**RE: CSU – Advanced Technology Campus Initial Review Comments  
File No. CPC A 20-00143, CPC ZC 20-00159, CPC MP 20-00160**

## **COMMENT RESPONSE LETTER**

MASTER PLAN  
SHEET 1 OF 1

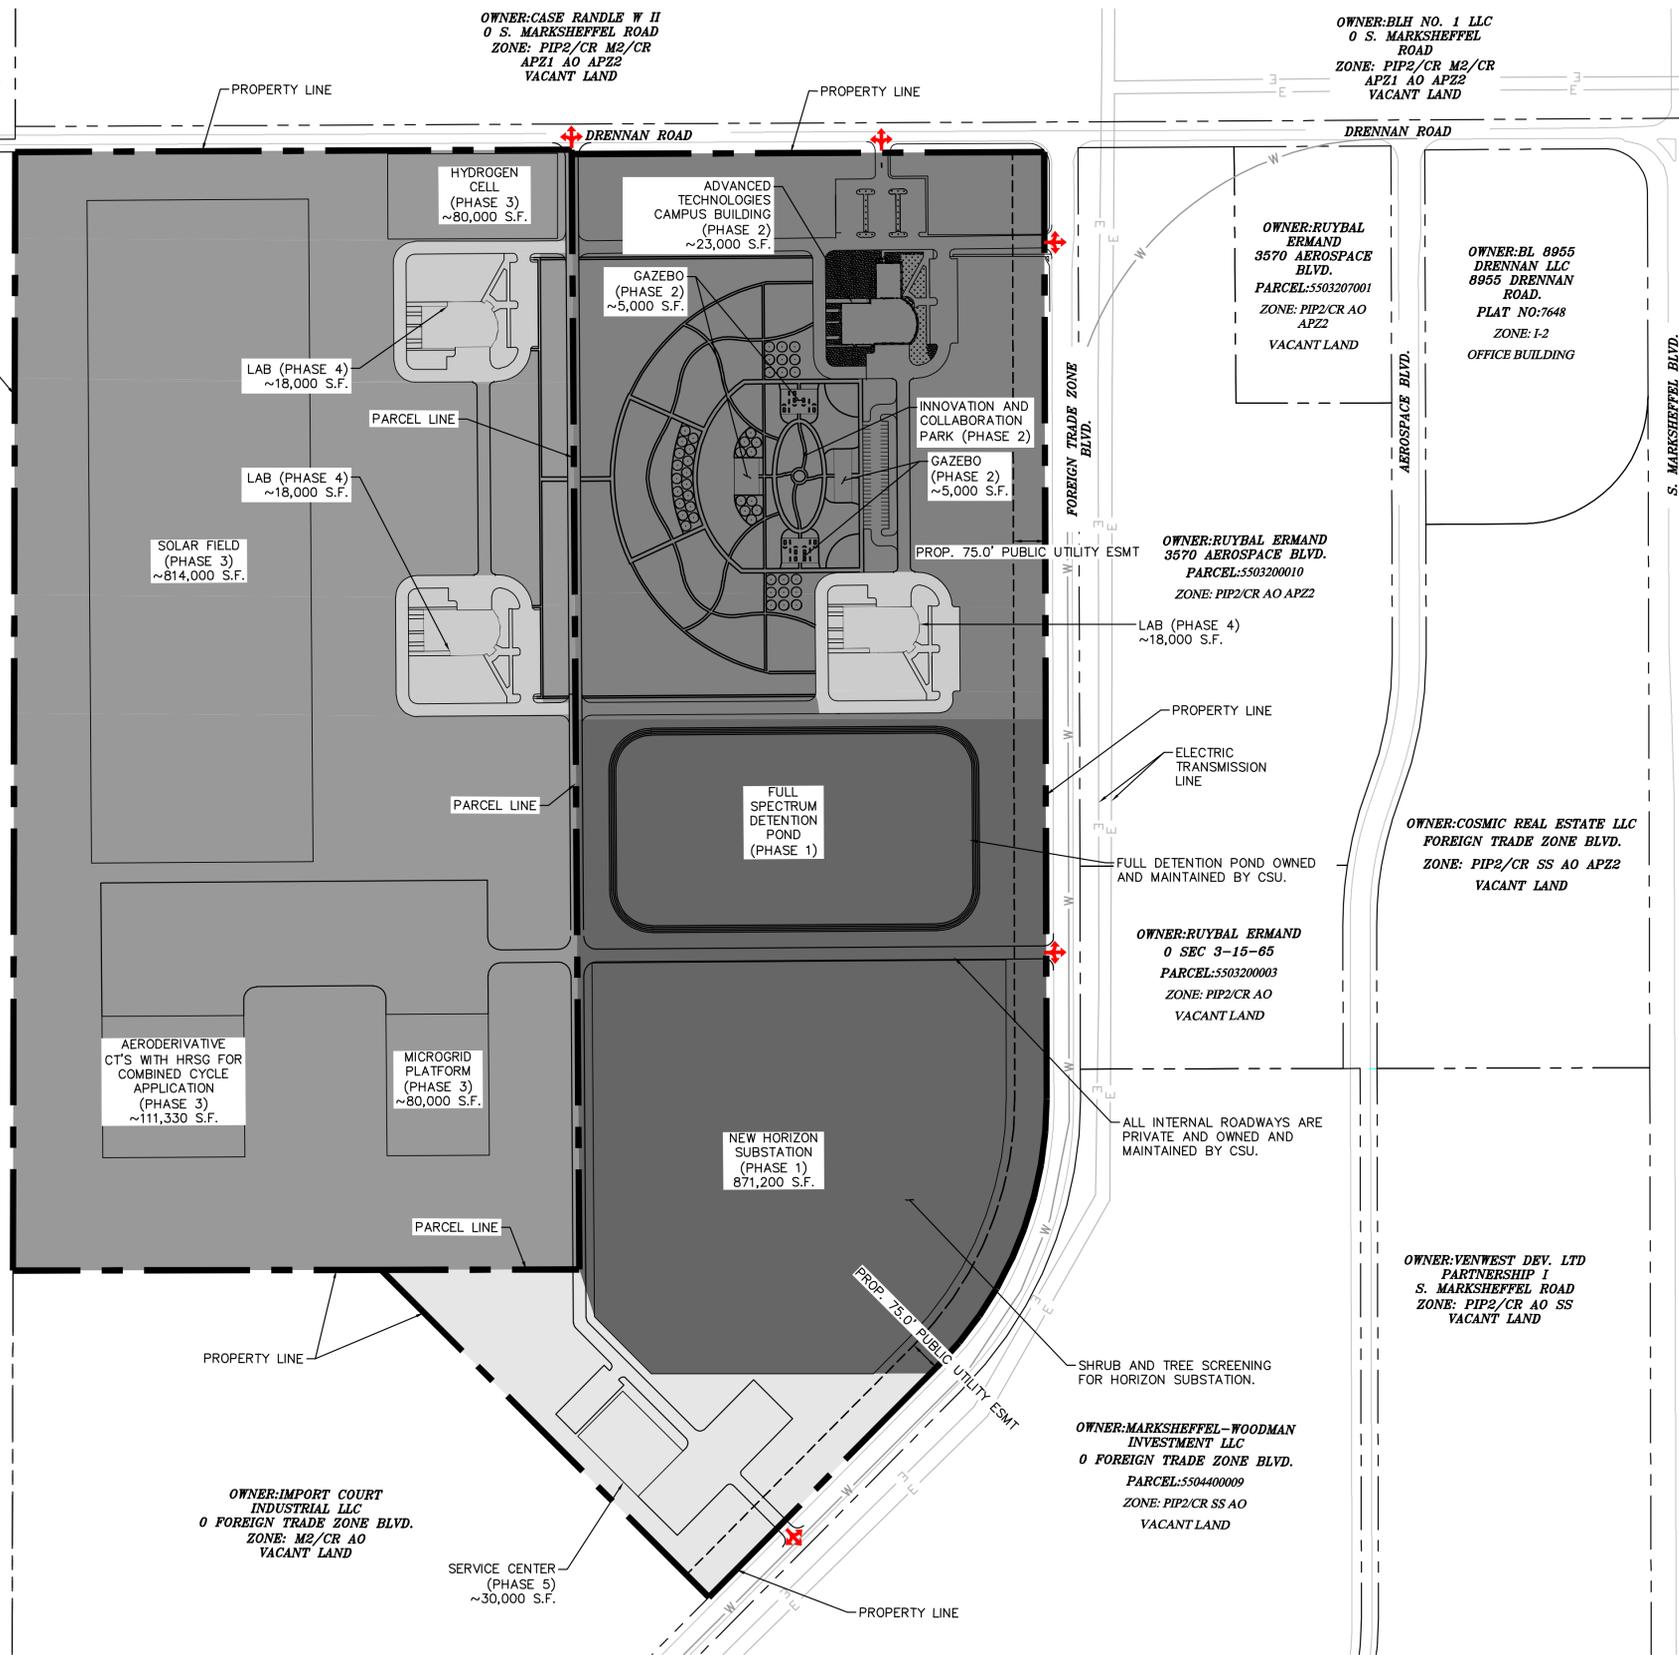
3. Site Data/Land Use – add or correct the following to the site data on sheet one of the plan:
  - A. Update the legal description per surveyor comments

- B. Add existing zone district: El Paso County I-2/A-5/CAD-O
  - C. Add proposed zone district: City of Colorado Springs PF/AO (Public Facility with Airport Overlay)

- A. Add a notes section to reflect all notes as identified below from City Engineering and Traffic
    - *Response: Traffic notes added.*
  - B. Add a note that all internal roadways will be private and owned and maintained by CSU. (Can you also clarify if this property will have secured access? This may change comments from CSFD.)

- *Response: Shrubs and trees will screen the substation. Note added to plan sheet.*
  - D. Staff wants to clarify if there would be any significant noise created from any portions of the facilities operating on site, if so add a note so it is clear to future surrounding development the potential noise impacts

- *Response: There will be no significant noise impacts to surrounding developments.*
5. Add access arrows to show future access points from Drennan Road, Foreign Trade Zone Blvd, and future internal roadways.

- *Response: Access arrows added to all road intersections.*
6. Please remove floorplan data from plan.
  - A. If preferred more detailed line work can be removed across the depictions. Most important are access, use and a general understanding of building/layout.

1. Label Full Spectrum Detention Pond as being maintained by Colorado Springs Utilities.
  - *Response: Note added.*

- *Response: Zone District has been added and Legal Description updated.*
4. Since there is no annexation agreement with this City annexation Planning staff would like to see a notes section added to the Master Plan to reflect items below to include:

- *Response: Note added. Only secured access will be to the horizon substation.*
  - C. Add notes to clarify the intent of the property to be screened/ buffered.

- *Response: Floorplan was removed from the building.*
7. Include zone districts and land uses on adjacent properties
  - *Response: Zone districts and land use added adjacent properties.*
